Development Facilitation Team (DFT) – Review Comments

DRB Project No: PR-2020-003222 Date: 5/24/2023 Agenda Item: NA Zone Atlas Page: B-13

Legal Description: Tract B-4-A Cottonwood Mall

Application For: PS-2023-00024 – Sketch Plat (DFT)

Plat for
Tracts B-4-A-1 & B-4-A-2,
2nd Revision Cottonwood Mall
Being Comprised of
Tract B-4-A,
2nd Revision Cottonwood Mall
City of Albuquerque
Bernalillo County, New Mexico
May 2020

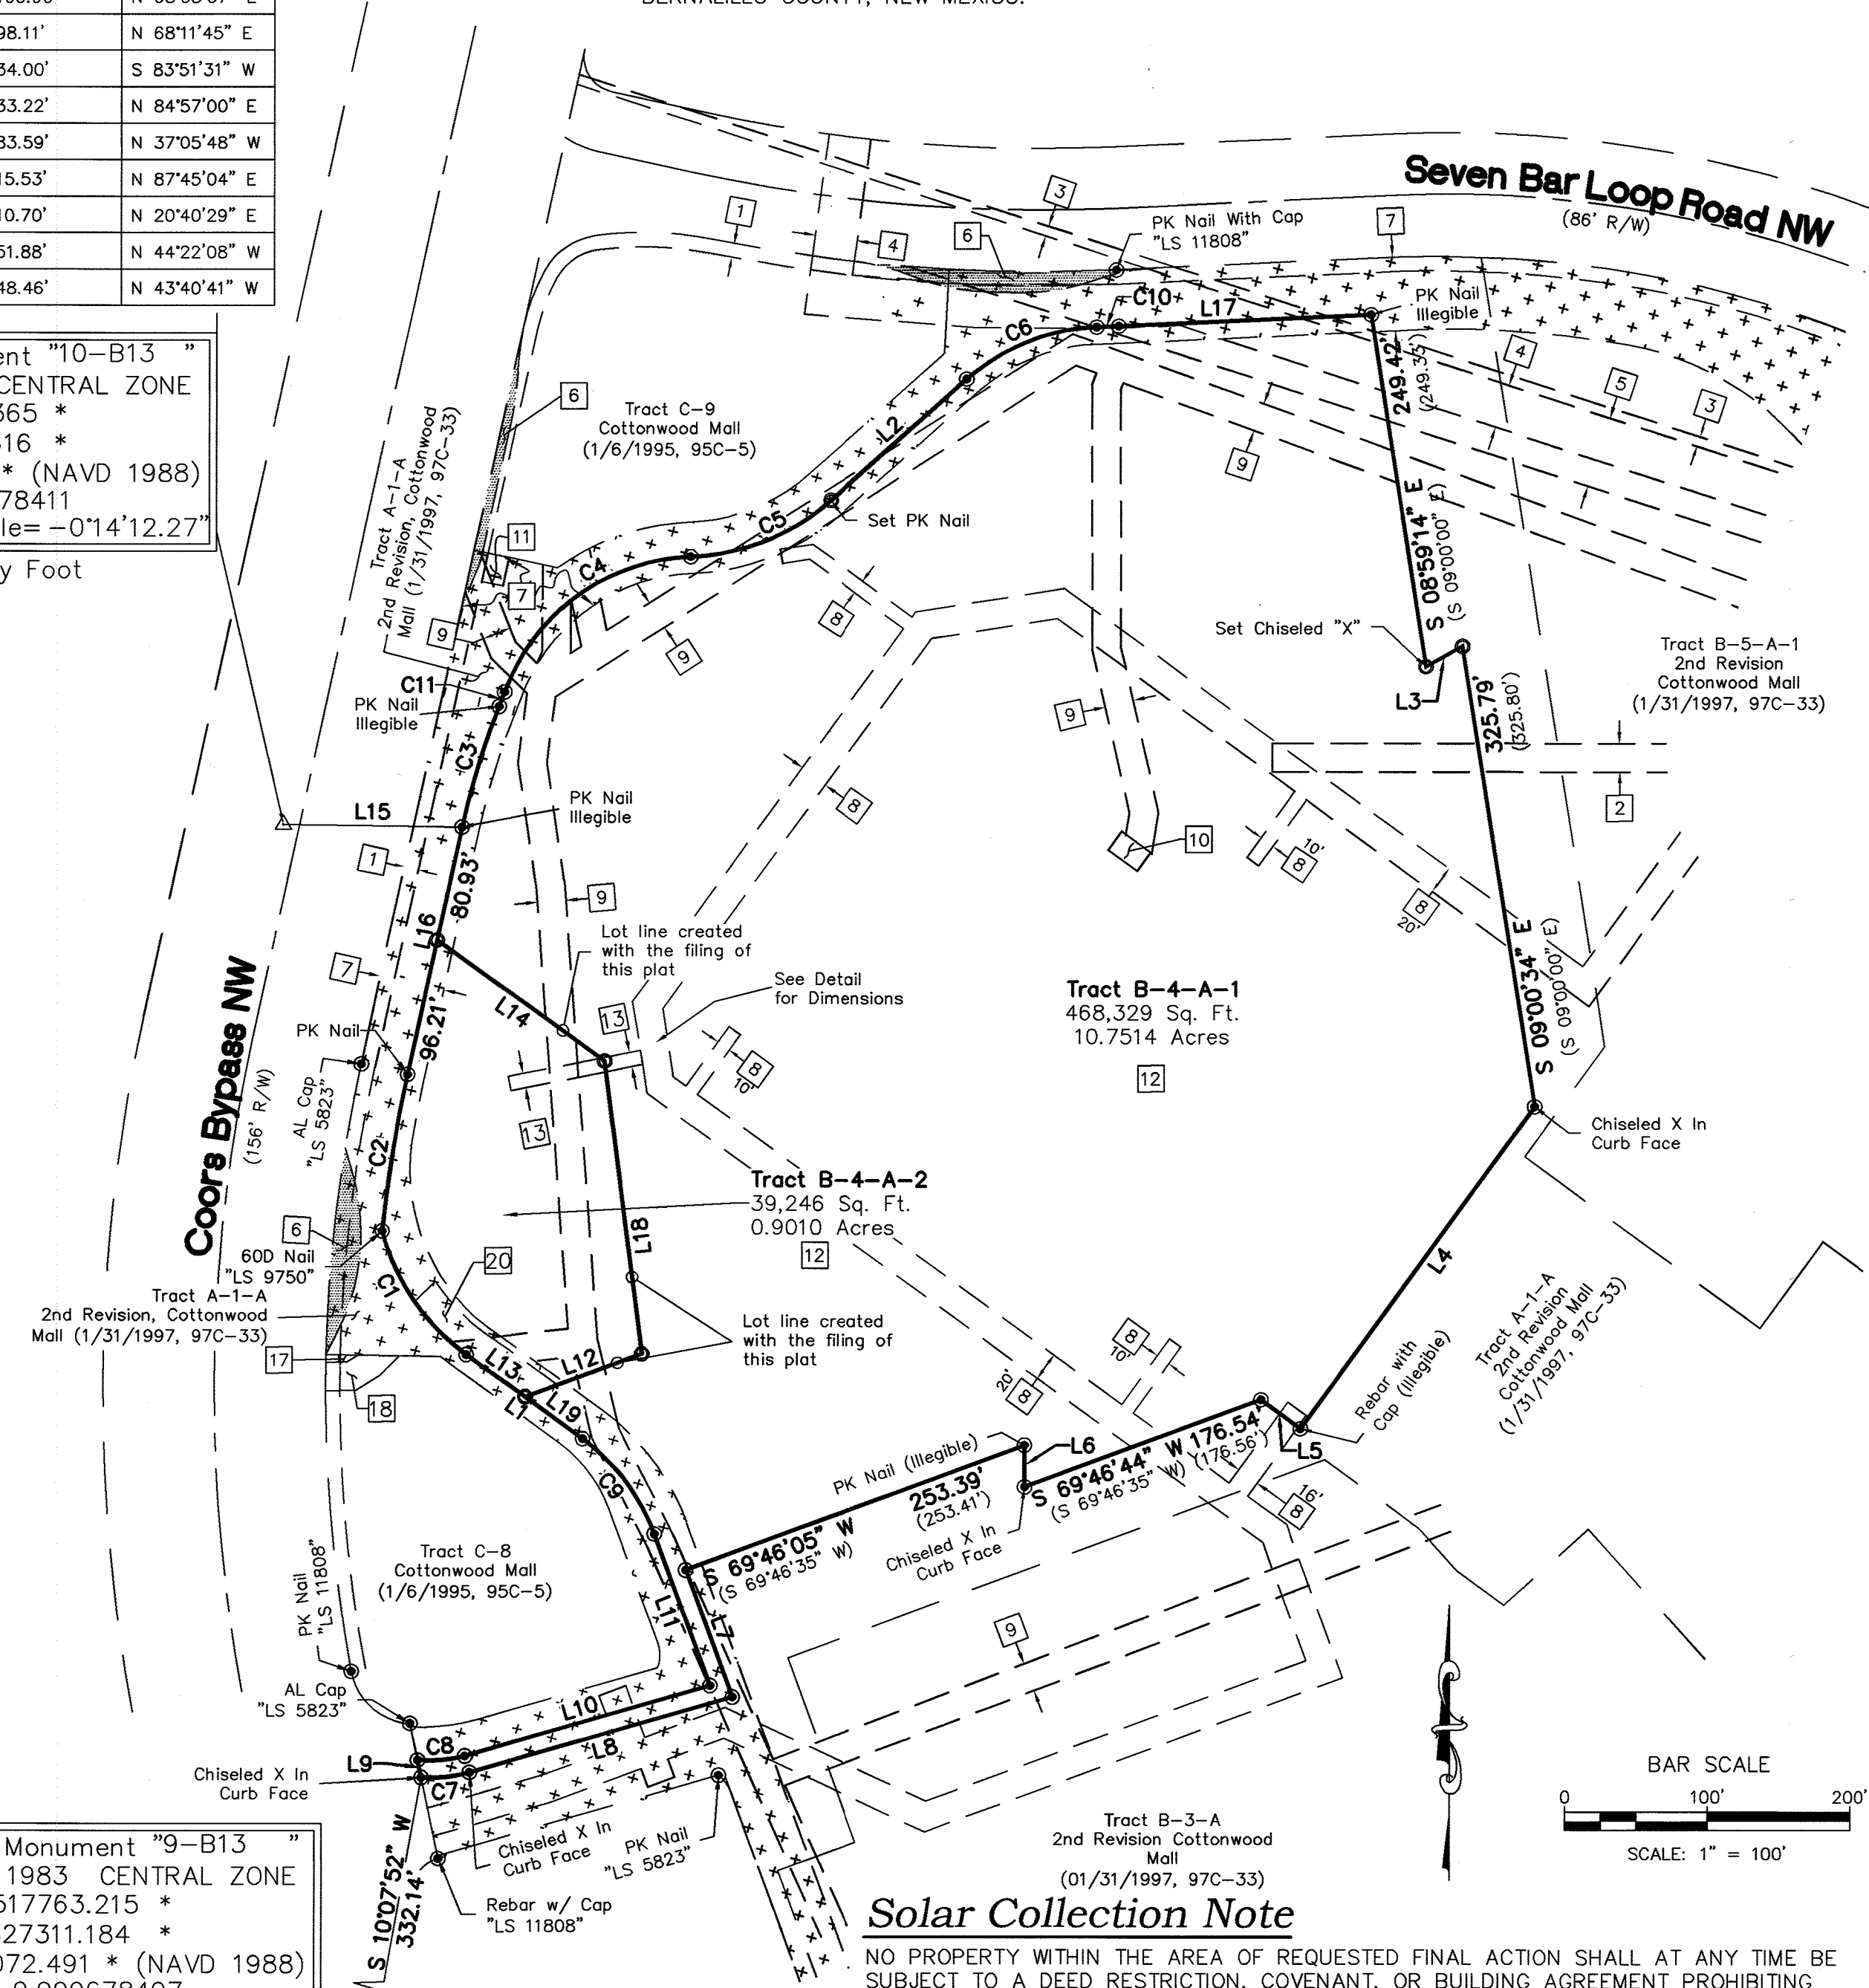
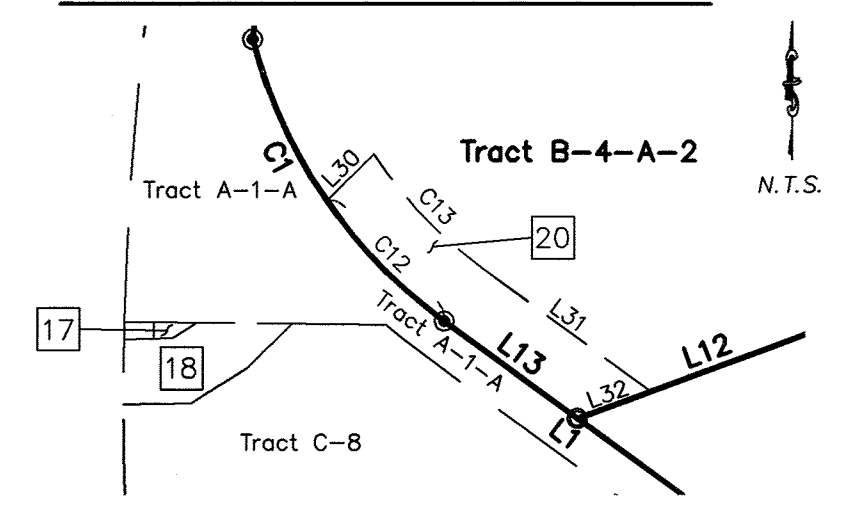
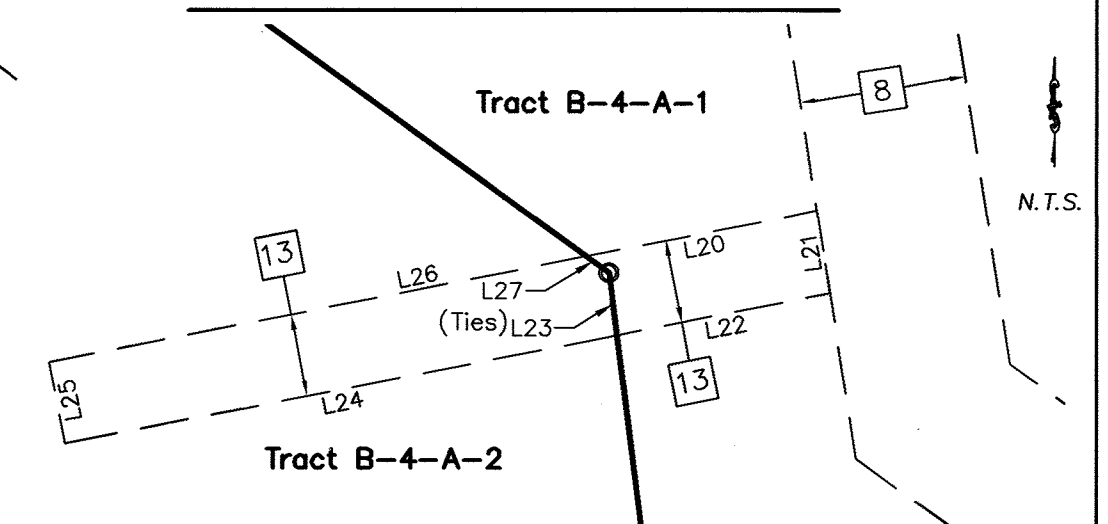
1. There is an existing serviceability letter 230203 and approved service connection agreement executed for the site that provides conditions for service for the site to develop a commercial development on the subject site.
2. No objection to the proposed plat however, please provide a document number for the proposed private sanitary sewer easement or show it as being granted as part of this plat.
